RE: Response under Section 131 of the Planning and Development Act 2000 (as amended) — Application for Substitute Consent, Murray Brothers Tarmacadam Ltd., Ardcahan Quarry, Dunmanway, Co. Cork

Case reference: ACP-324277-26

Section 131 notice dated: 27 August 2026 (second Section 131 notice in this matter)

Appendix C – Combined Substitute Consent Remediation and S37L
Regeneration Plan (composite drawing prepared for this response)

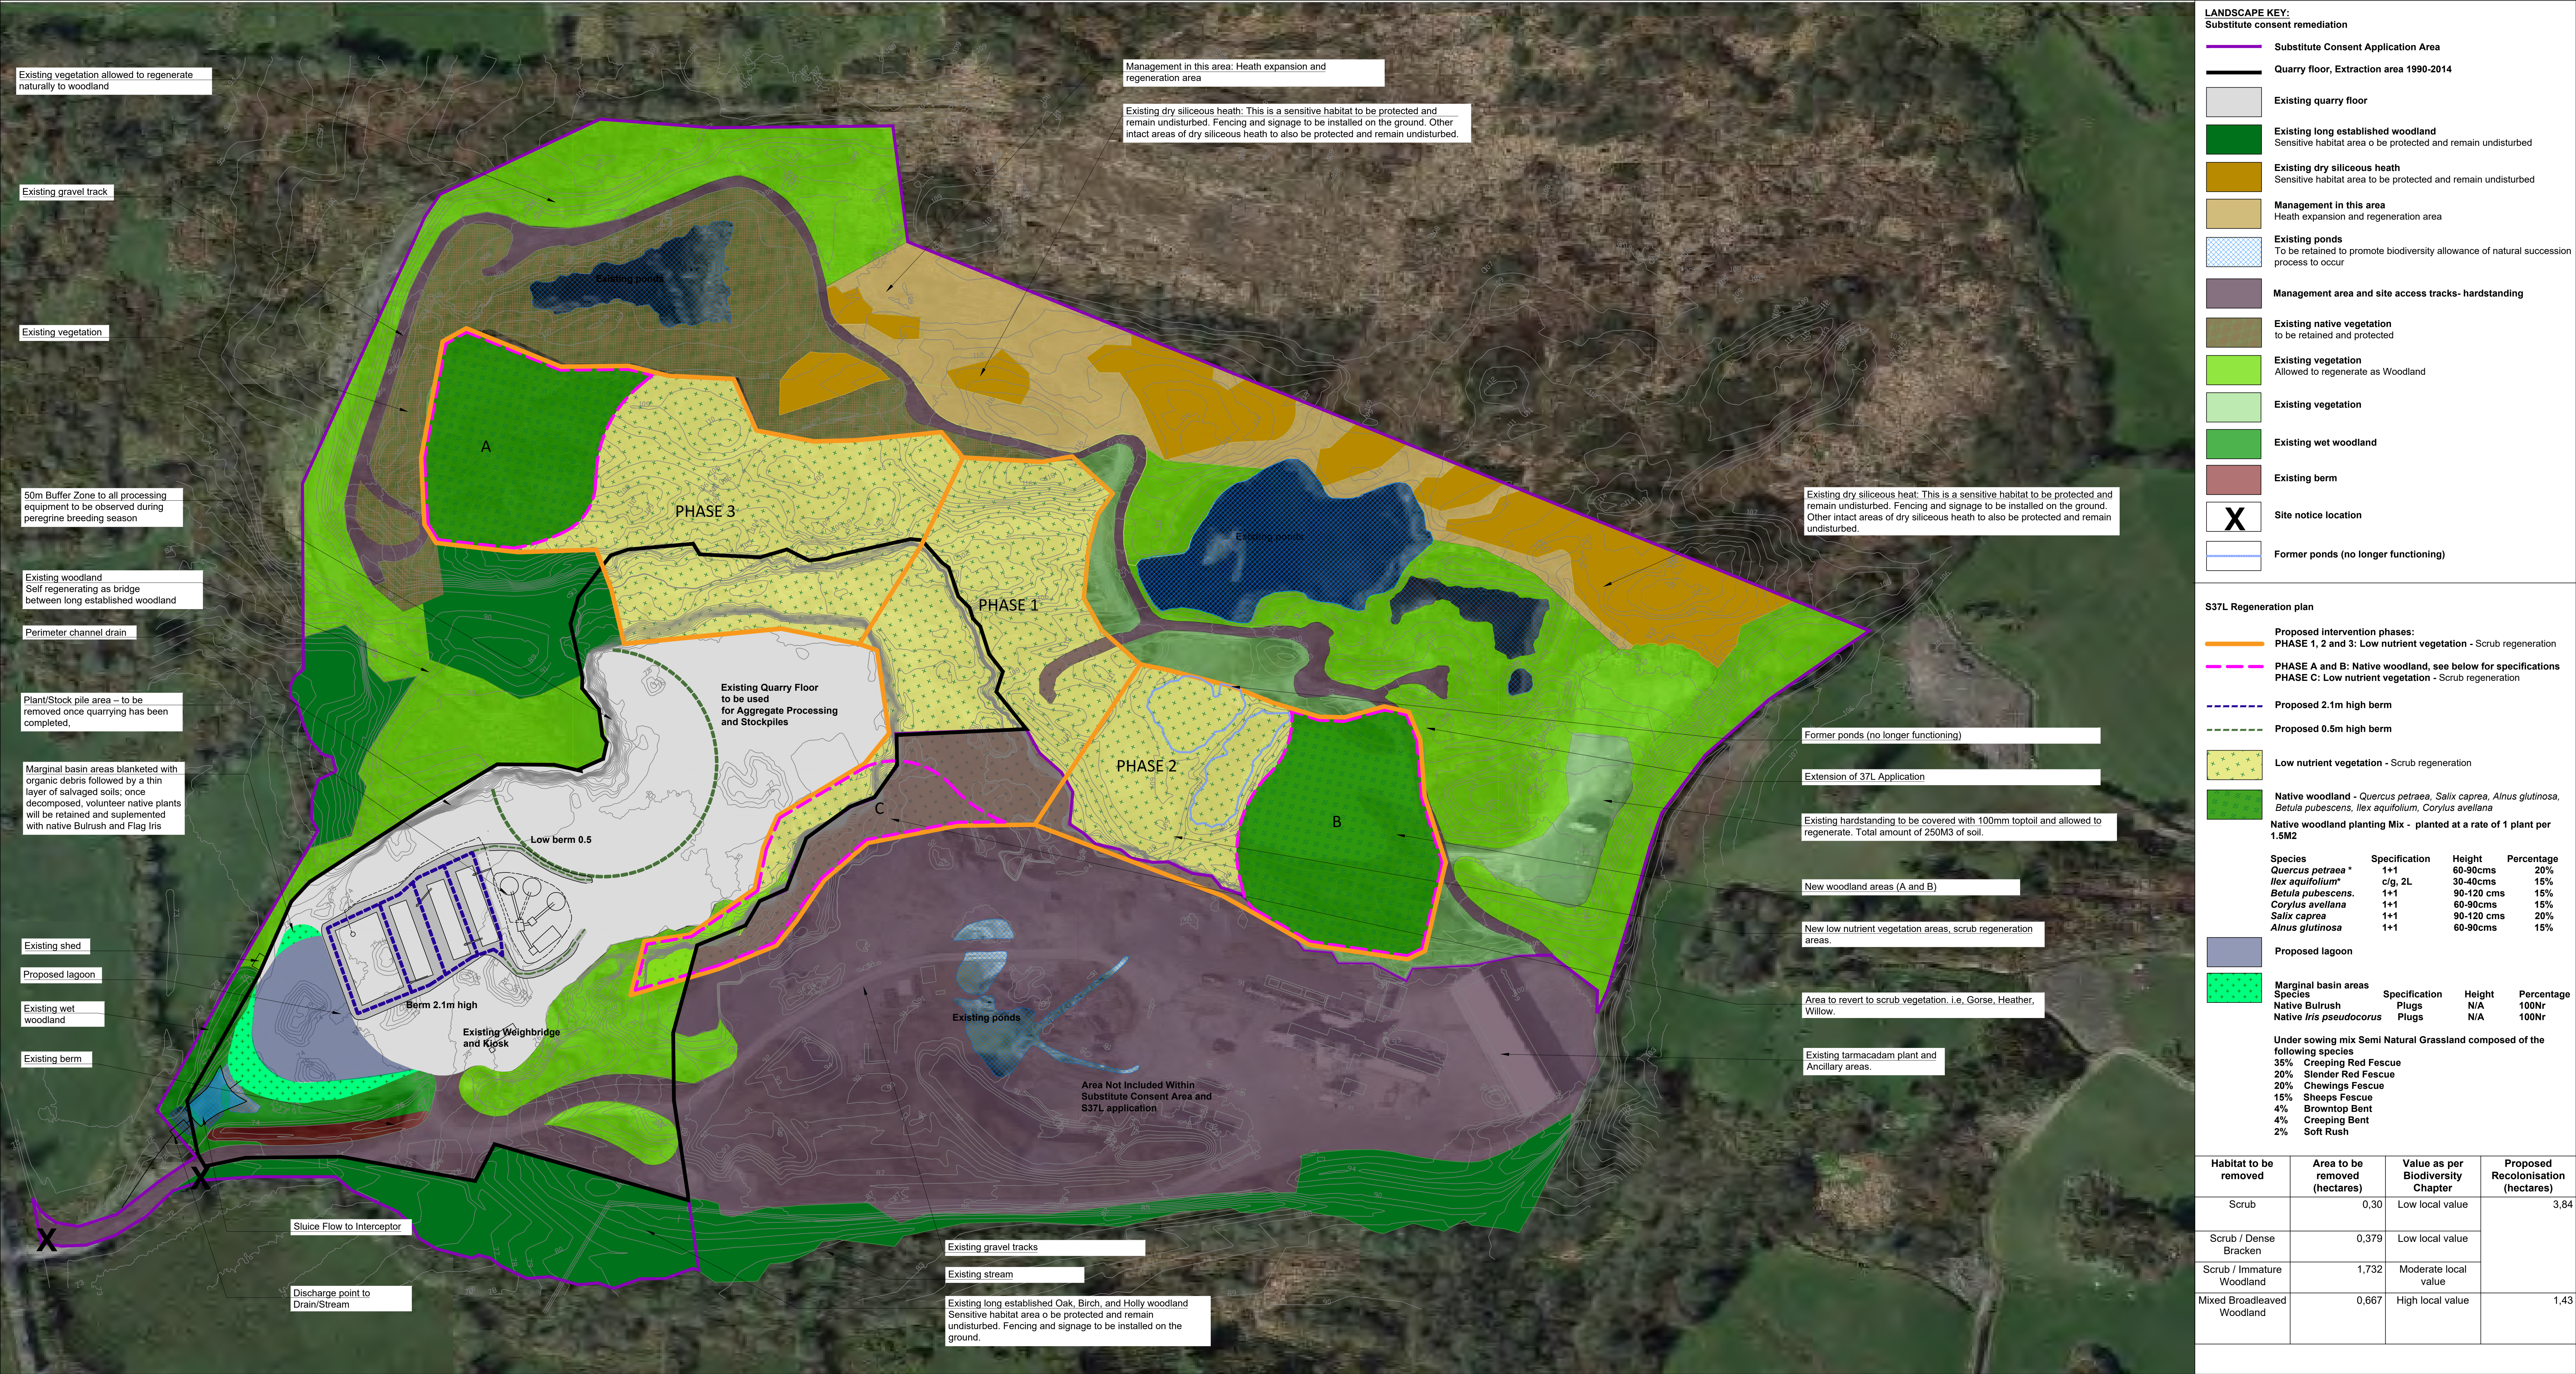
The Applicant reaffirms at page 4 that the loss of Annex I habitats is "the principal significant adverse environmental effect associated with the quarry development" and that the loss of Old Sessile Oak Woodland (91A0) and European Dry Heath is "irreplaceable". It then states expressly:

"[T]he purpose of the Substitute Consent application is to assess and regularise development already undertaken and to determine whether appropriate remedial measures are proposed, rather than to secure offsetting for all historic habitat changes on a hectare-for-hectare basis."

This position is directly at odds with the Cork County Council Ecology Officer's recommendation of 13 July 2026 that "a revised remediation plan" be submitted "where the full extent (ha) of each habitat identified to be of at least high local value which has been removed or damaged during the period of relevance would be quantified in the plan, and that significant additional efforts be put forward to compensate for the impacts incurred." The Applicant is now on record as declining the very approach the Planning Authority has recommended. That position cannot be reconciled with Section 177K(1J)(e) (extent of remediation) and is a further ground for refusal.

Figure 3. Freshwater Pearl Mussels close to Ardcahan Quarry

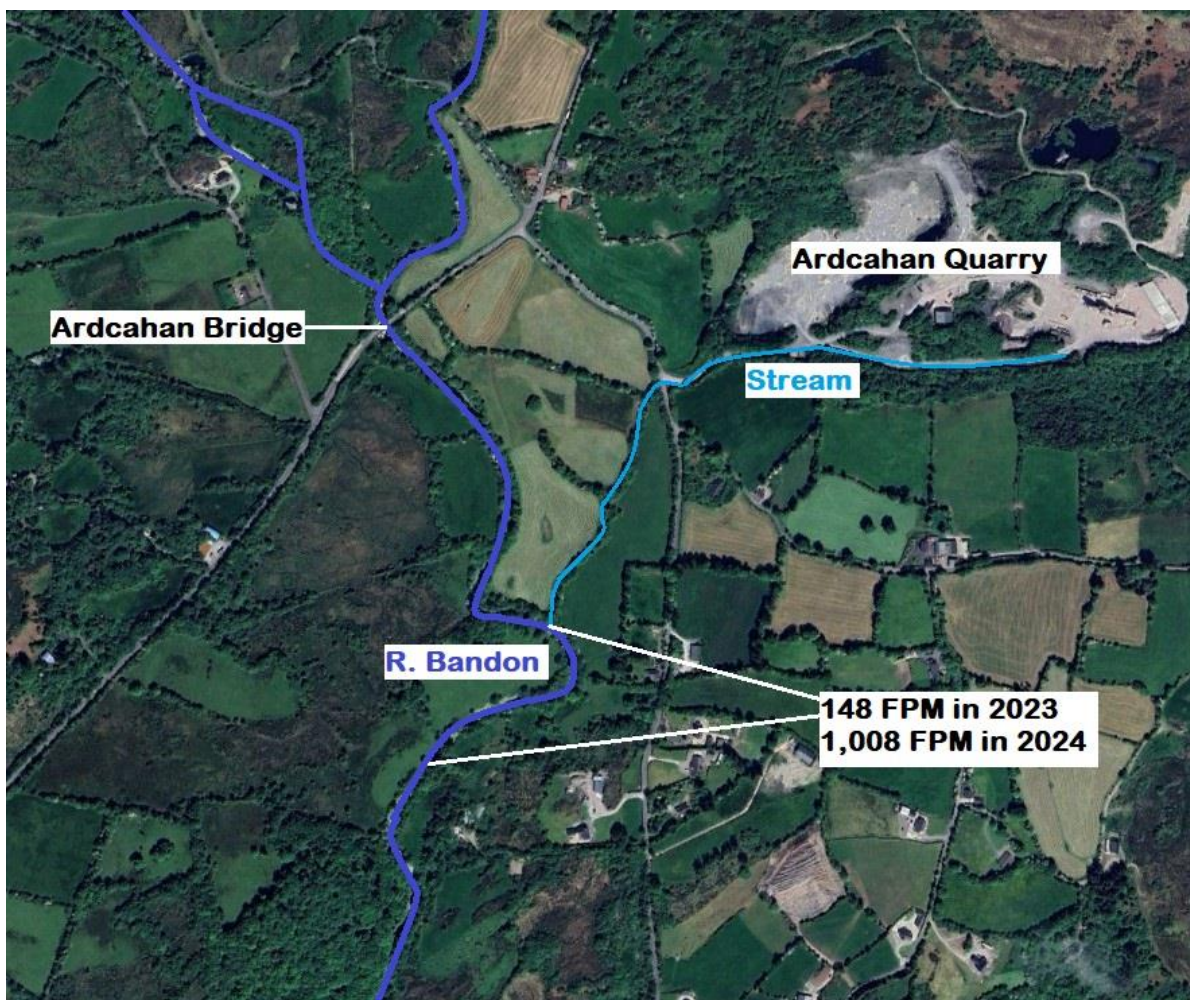
The Applicant relies at page 3 of its response on the recording of “1,008 mussels” during the 2024 survey as evidence that quarry operations did not adversely affect the adult population. That figure does not answer the case for two reasons.

First, the concern is not the survival of long-lived adult mussels, but juvenile recruitment. The NPWS site-specific Conservation Objectives for the Bandon River SAC (002171, 6 August 2019), as cited in the Hayes observation at Ground 2, record the population as “unsustainable owing to lack of survival of juvenile mussels”. Adult mussels can live over 100 years. Their present survival does not indicate the population is viable. The population is unsustainable notwithstanding those adult numbers, and the rNIS itself concedes at Section 7.1.2.2 a likely contribution to “medium to long-term negative effects on the quality of juvenile pearl mussel habitat within the Bandon River SAC”. That is the very attribute on which the population's long-term survival depends.

Second, the Hayes observation at Section 5 notes that the applicant's own Appendix 14.2 (FWPM survey) records an unexplained downstream increase from 148 mussels in 2023 to 1,008 mussels in 2024 "outside the normal margin of error". The Applicant's response does not address this discrepancy or the surveyor's linking of a separate matter (fourteen mussels bedded under Ardcahan Bridge in 2022 and absent in September 2024) to the stream from the quarry. We address that separate matter briefly at Section 5 below.
